KITTITAS COUNTY

MEMORANDUM

SUBJECT: JN Agricultural Short Plat SP-15-00010

JN AGRICULTURAL SHORT PLAT SP-15-XXXXX

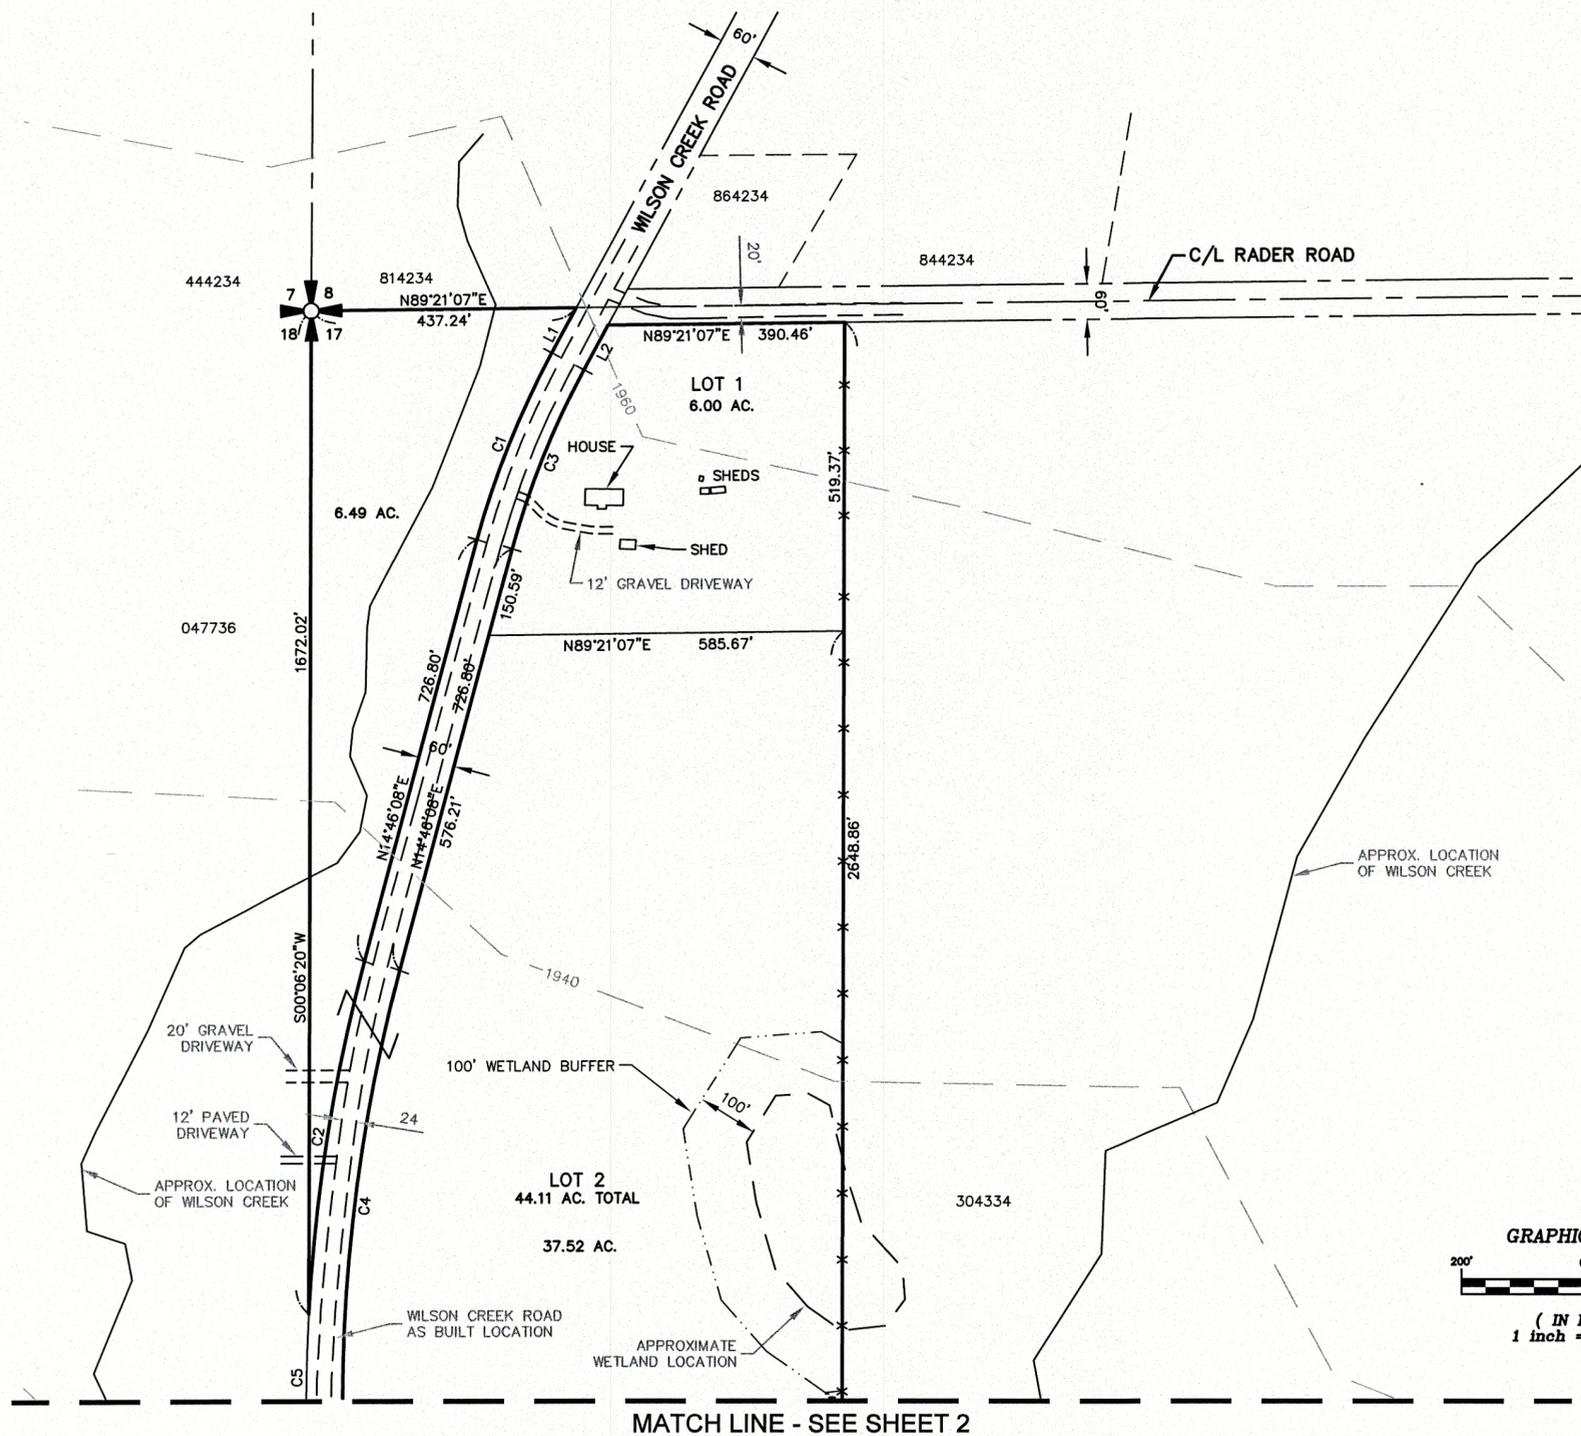
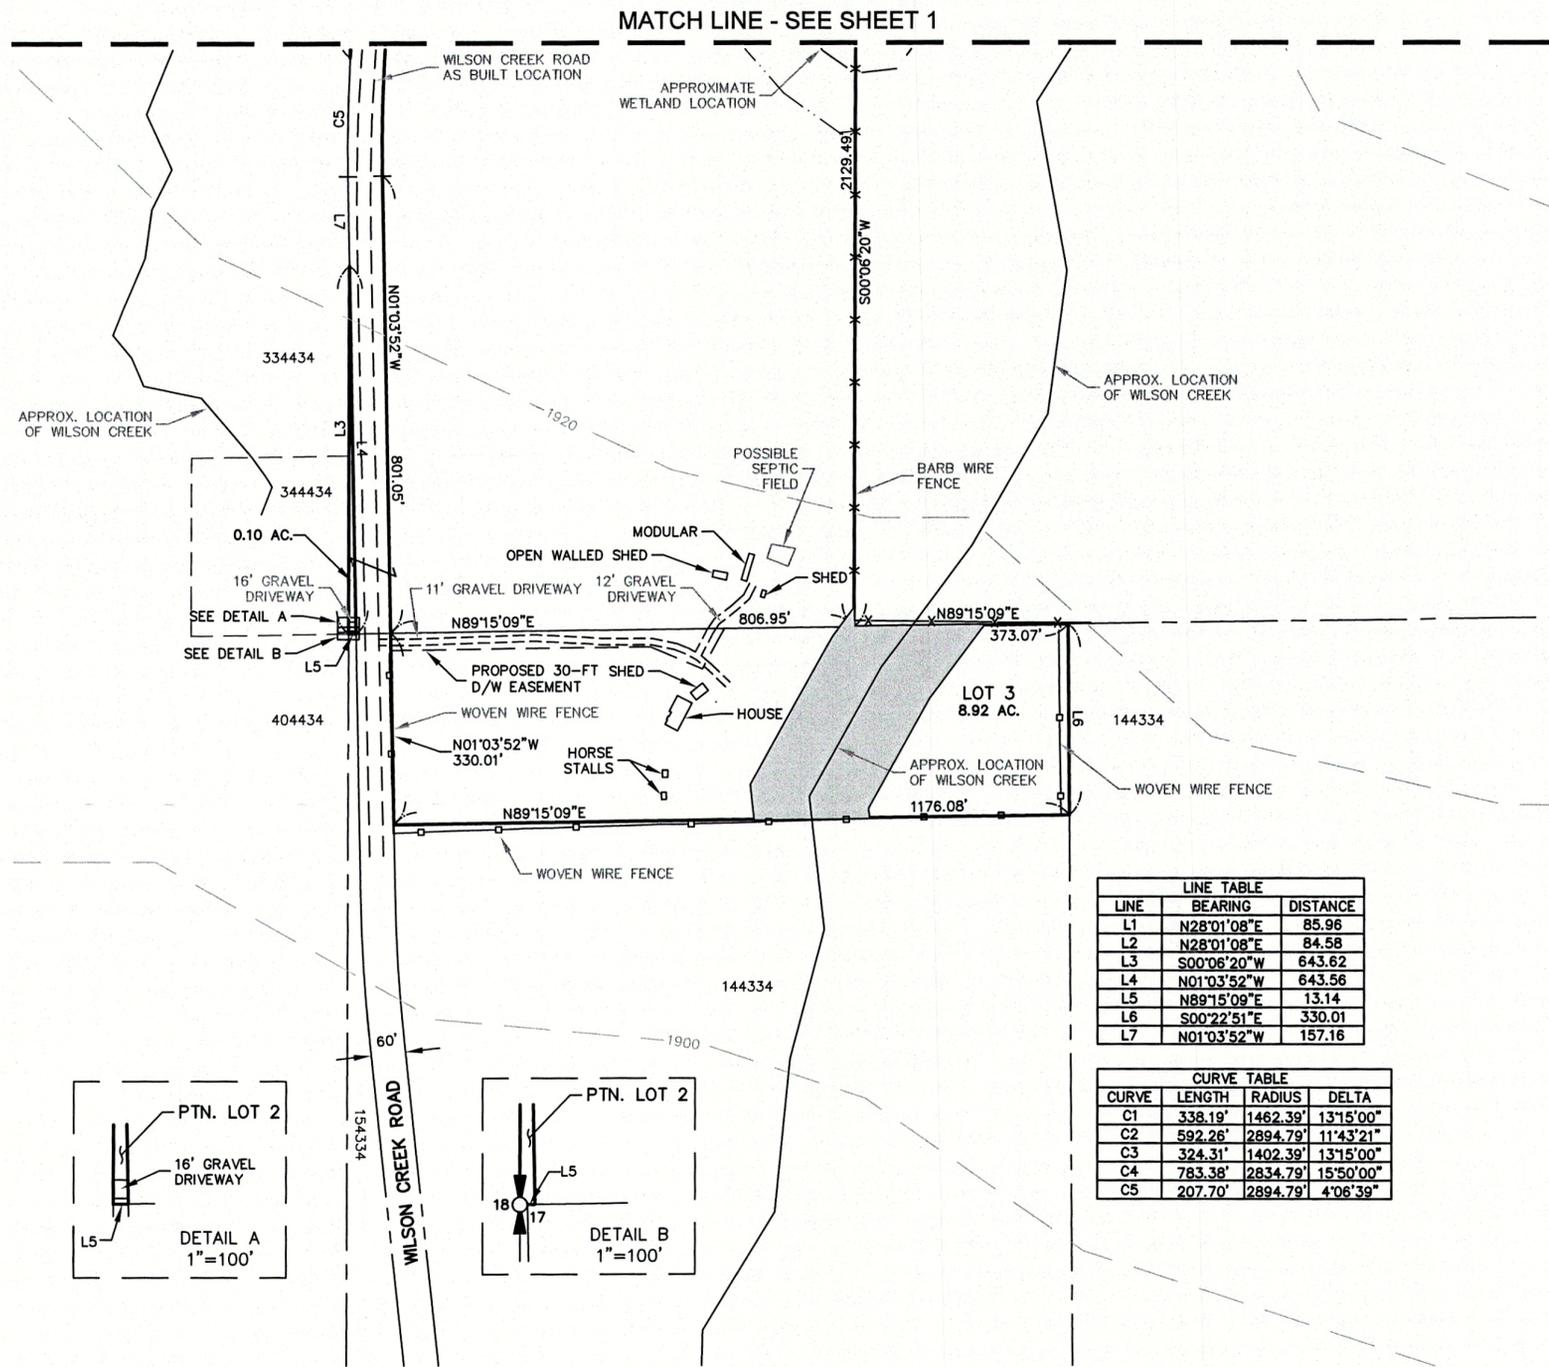
1. Transportation Concurrency Application: Needs to be submitted to Public Works.
2. Neighboring Property Access: Easements for access across lot 2, for parcels 047736, 334434 and 344434, need to be documented on the face of the short plat.

3. 100 year floodplain: 100 year floodplain located on westerly portion of lot 2, needs to be shown on the face of the short plat.
4. Driveways: A driveway shall serve no more than two tax parcels. See Kittitas County Road Standards, 12/15/15 edition.
